Engineers Comments Regarding Surface Water Drainage

Application Reference:	AL/13/25/DOC	Reviewer Reference:	ADC/EXT2/D2134/70
Planning Officer:	Hannah Kersley	Date of Review:	27.11.2025
Site Name:	Karenza Hook Lane Aldingbourne PO20 3TB		
Application Description:	Approval of details reserved by condition imposed under reference AL/154/23/PL (APP/C3810/W/23/3335883) relating to condition number 3 - Construction Management Plan, condition number 5 - surface water drainage scheme, condition number 8 - external materials and finishes and condition number 9 - energy.		
Assessment Number:	1 of 2

Response	Condition 5: Objection
-----------------	-------------------------------

APPENDIX B

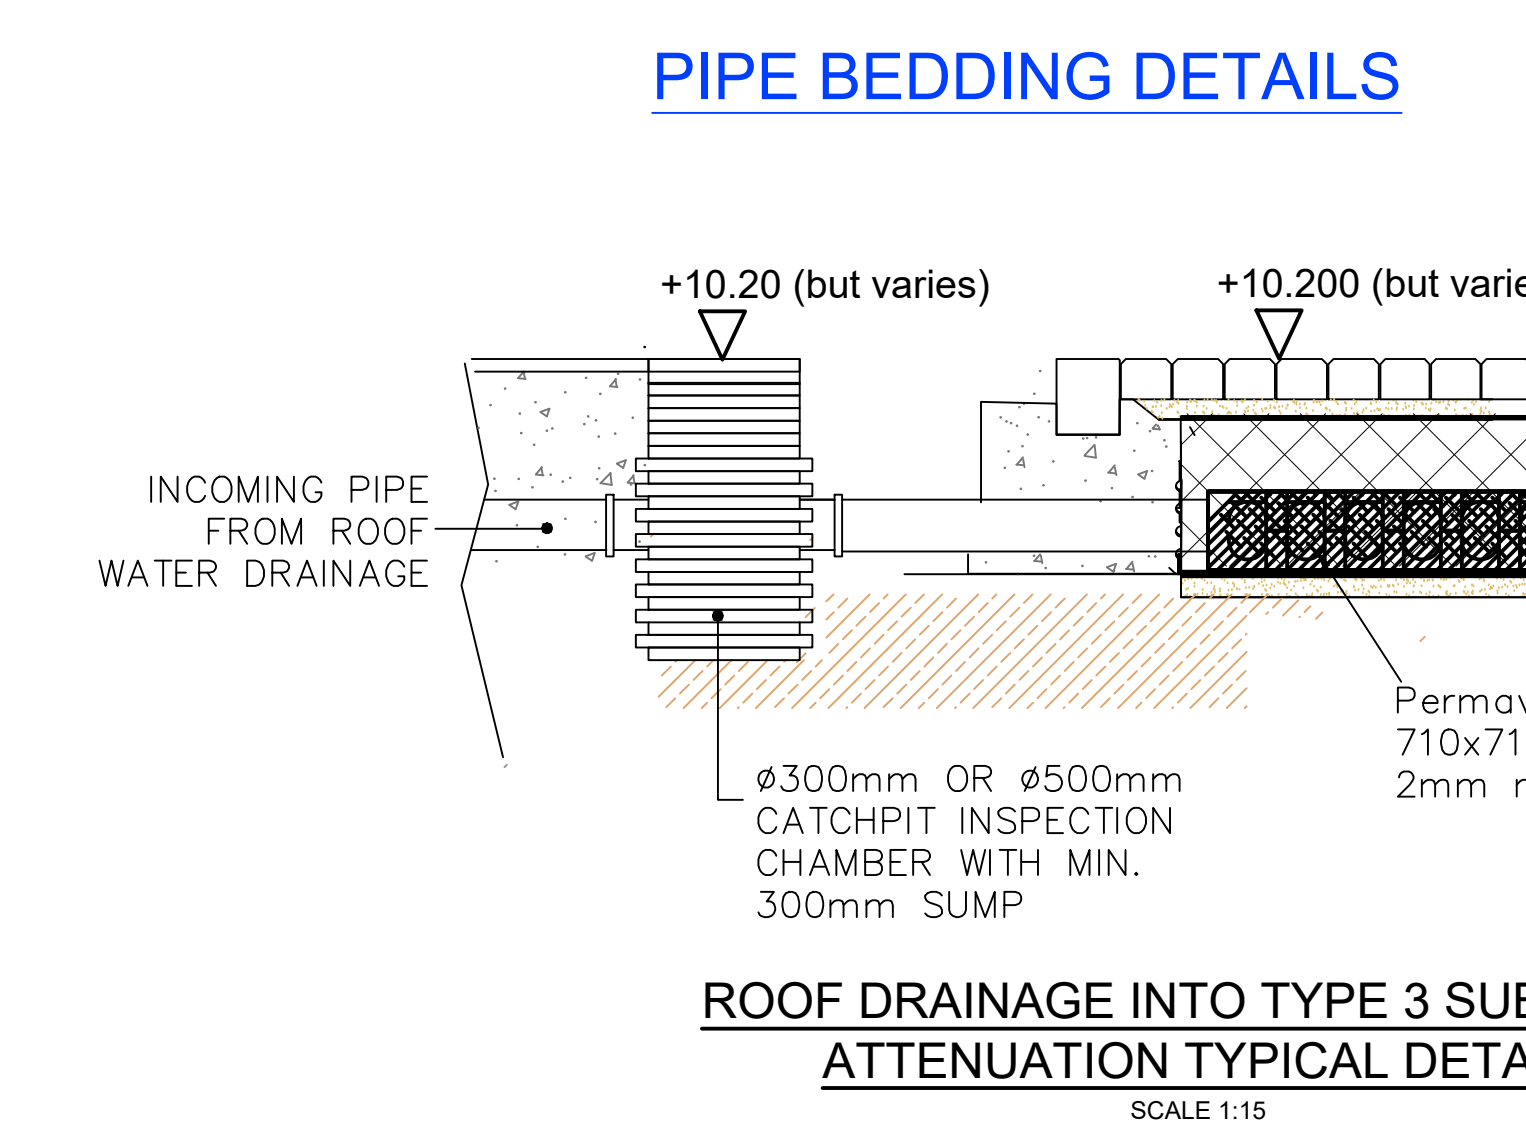
14.	ADC Drainage Comments 29/04/2025 The hydraulic calculations specify node SW-13 as a vortex flow control with an invert of 9.49m, however drawing 435050-221P2 shows this to be higher @ 9.494m. As cited above, for certainty the as-built levels must be used as they may not correlate with the phase 1 design. Designer Response 25/06/2025 Amended in the model	To clarify this is now SW-14 in the revised calcs with the correct invert. Comment closed.	OK		
15.	ADC Drainage Comments 29/04/2025 The hydraulic calculations specify several nodes as 700mm diameter which is not a recognised manhole/IC chamber size. Designer Response 25/06/2025 Updated to as built 450mm dia	S11, S12,S13,S14 are noted to be 500mm control chambers. Comment closed.	OK		
16.	ADC Drainage Comments 29/04/2025	Comment closed.	OK

18.	ADC Drainage Comments 29/04/2025 The cover level and invert levels for numerous nodes do not appear to correlate wholly with drawing 435050-221P2. Designer Response 25/06/2025 updated	Comment closed.	OK		
19.	ADC Drainage Comments 29/04/2025 Please explain wat is the relevance of a 1:500 return period has been demonstrated, also with CC. Designer Response 25/06/2025 This has been removed	Comment closed.	OK		
20.	ADC Drainage Comments 29/04/2025 Drawing 435050-221P2 is very difficult to review where phase 1 is greyed out and the key does not clarify all items i.e. its is assumed the pink text represents the phase 1 formation levels?	Comment closed.	OK

Designer Response 25/06/2025 The revised drawing is clearer and also the construction issue of phase 1 has now been provided				
21.	ADC Drainage Comments 29/04/2025 Drawing 435050-221P2 requires formation levels at all corners and at outlets/inlets of all permeable pavements. Designer Response 25/06/2025 This has been added	Comment closed.	OK		
22.	ADC Drainage Comments 29/04/2025 Rainwater pipes run through silt traps (catchpits) and into the permavoid. Please provide a construction detail of how this is interfaced. Designer Response 25/06/2025 Detail provided on Drawing 435050-222P	Comment closed.	OK		
23.	ADC Drainage Comments 29/04/2025	Comment closed.	OK

Please provide construction details for all features identified on drawing 435050-221P2. Designer Response 25/06/2025 Detail provided on Drawing 435050-222P				
24.	ADC Drainage Comments 29/04/2025 Measures to protect the permeable pavement (asphalt construction) during the construction period must be annotated on the drawings to ensure that it does not become silt up prior to completion of the project. Designer Response 25/06/2025 See details on drawing 435050-222P	Comment closed.	OK		
25.	ADC Drainage Comments 29/04/2025 Please provide details of the foul drainage routing so this can be reviewed in conjunction with the surface water drainage.	Still missing on drainage GA drawing 221P. Comment outstanding.	Foul added to layout	Noted. Comment closed.
